| Consultation Response from: KC Environmental Health (Pollution & Noise Control) | | |
| 2023/91210 - Thornton And Ross Ltd, Manchester Road, Linthwaite, Huddersfield, HD7 5QH | | |
| Discharge condition 6 (noise barriers), 7 (finishes colour of plant and dimensions of pump and chiller) on previous permission 2021/92779 for erection of plant deck consisting of new heating, ventilation and air conditioning system (HVAC) with associated works | | |
| Responding Date: 10 May 2023 | Responding Officer: Mohammed Nasim | Responding Ref: WK202312168 |

Document Number
AAA5581-RPS-XX-XX-DR-A-0010

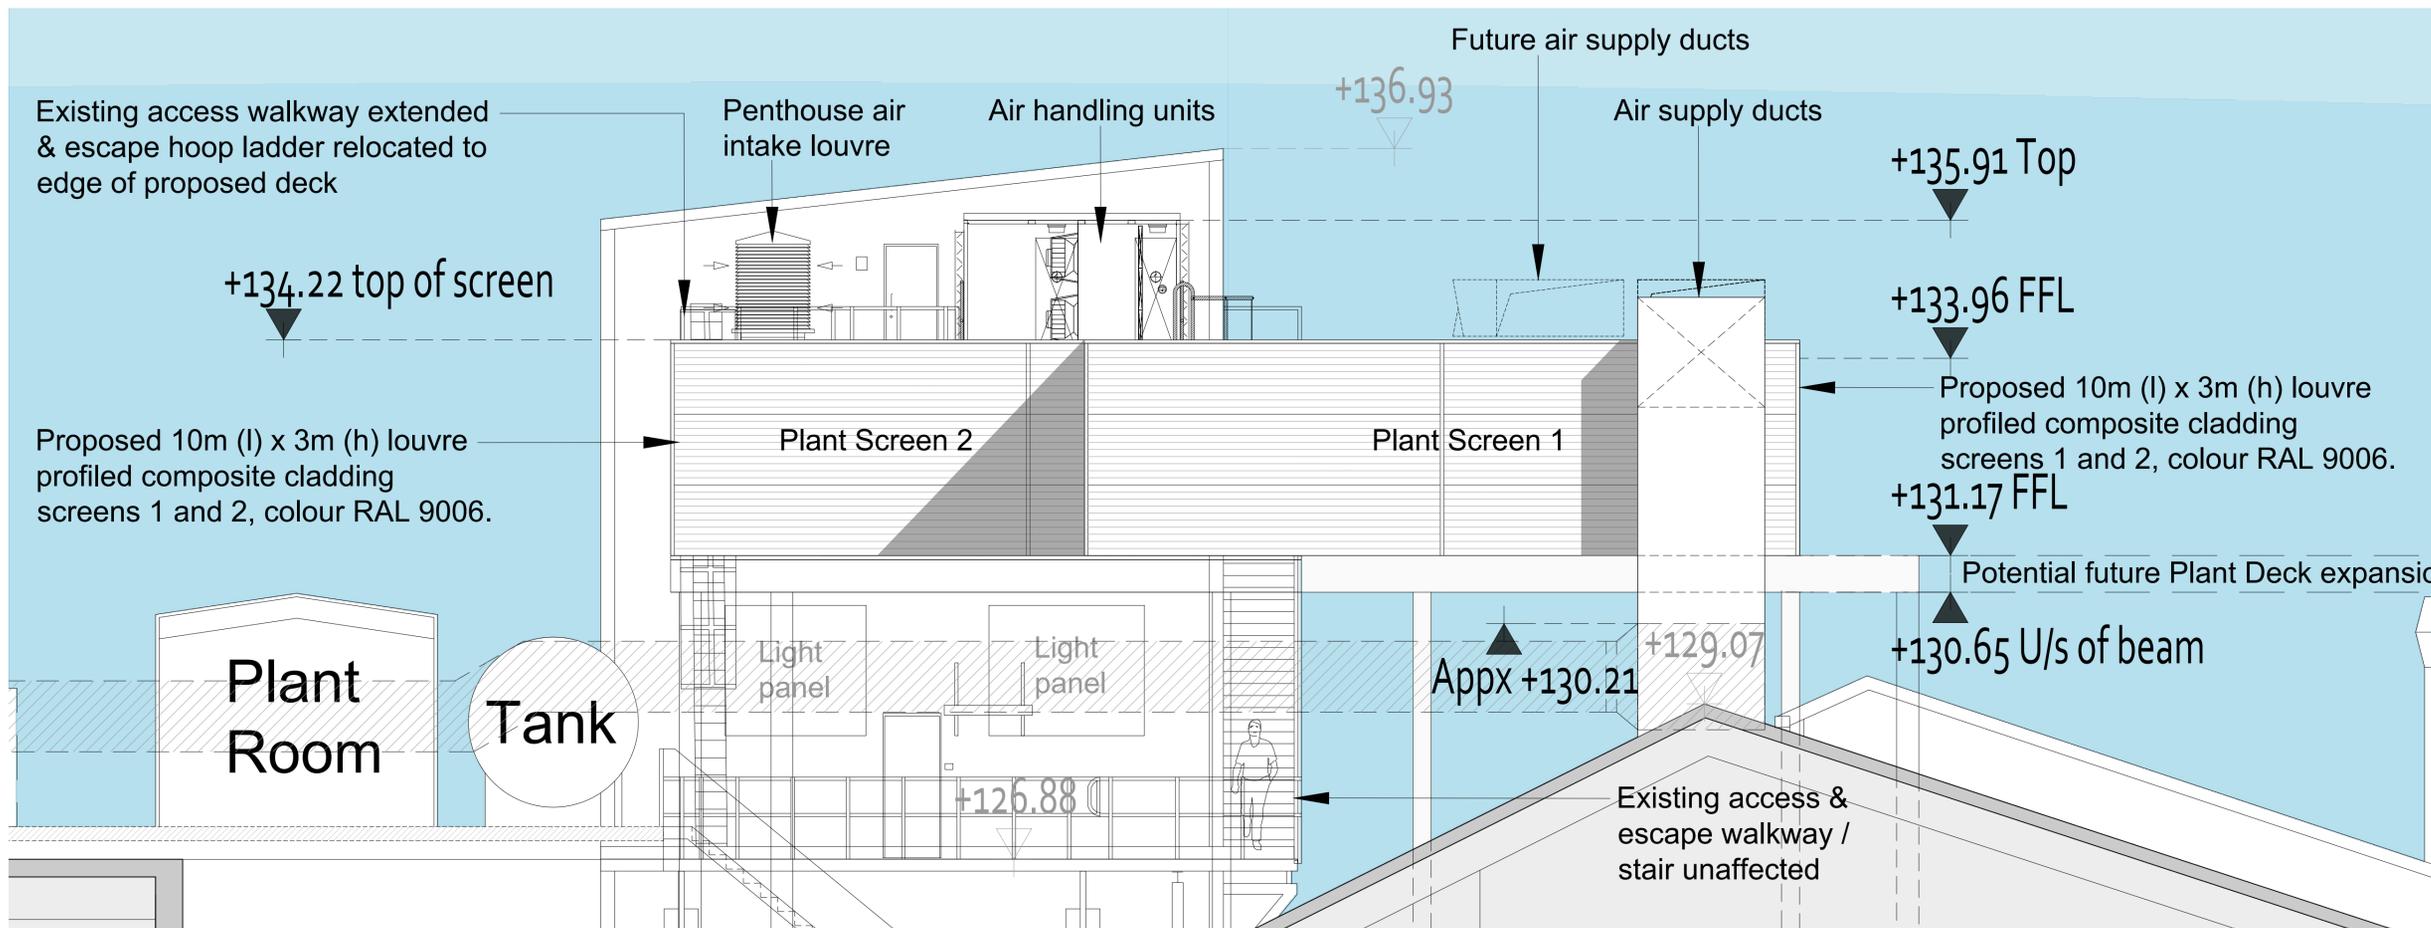
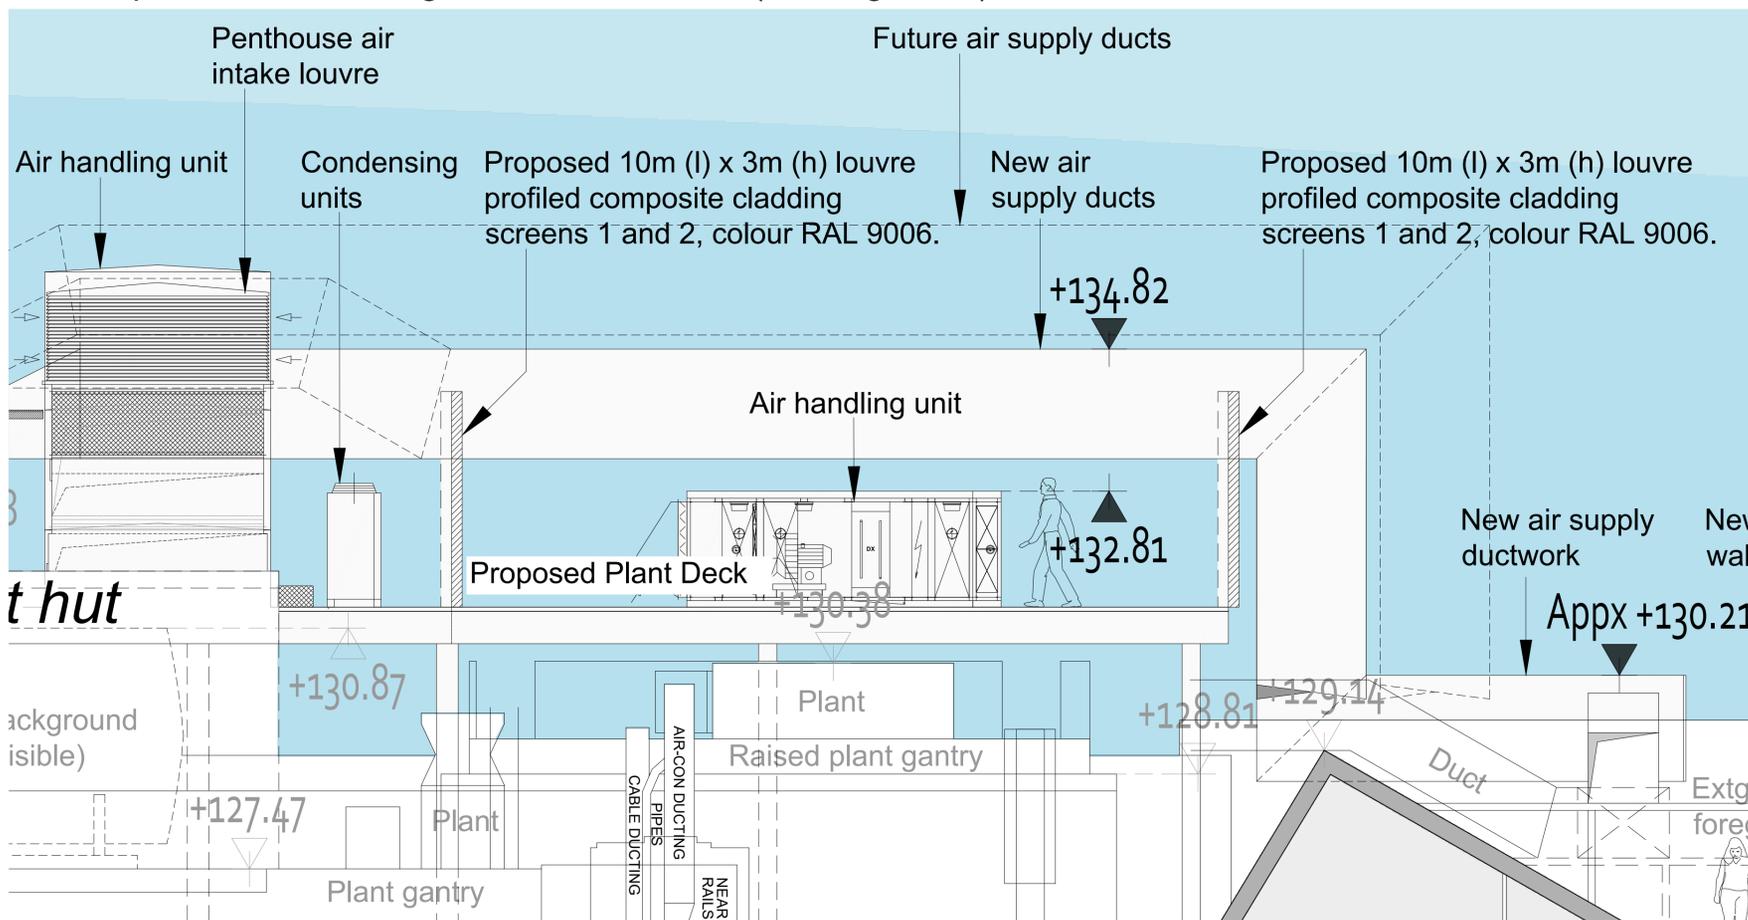
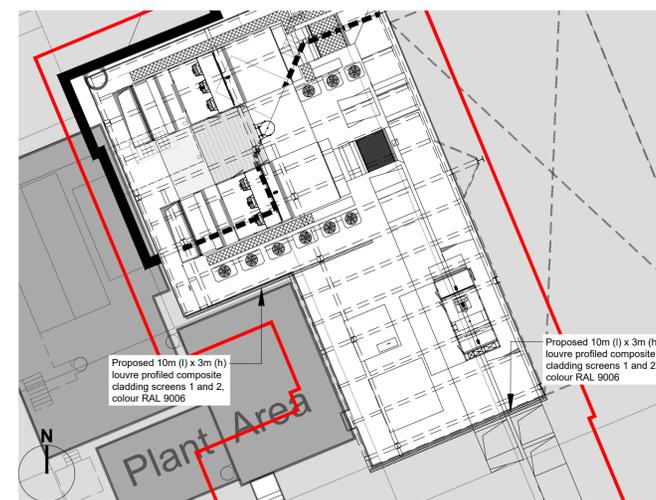
| <p><u>Comments</u></p> <p>In our comments dated 10 December 2021 (submitted under 2021/92779), we accepted the findings of the Noise Impact Assessment (NIA) authored by RPS dated 07 July 2021 Ref JAJ02698-REPT-01-R1. However, as there was some uncertainty in the final installation of mechanical plant and its respective attenuation, we requested an addendum report be submitted once details of the mechanical plant were finalised.</p> <p>In support of this application to discharge the condition, the applicant has submitted a Noise Impact Assessment authored by RPS dated 06 July 2021 Ref JAJ02698-REPT-01-R0 and it is noted that this NIA predates the one submitted under 2021/92779. It is therefore rejected.</p> <p>The applicant is advised to submit an up to date NIA to take into account the uncertainty within the Noise Impact Assessment dated 07 July 2021 Ref JAJ02698-REPT-01-R1.</p> <p><u>Recommendations</u></p> <p>We recommend condition 6 is not discharged at this time.</p> | | |
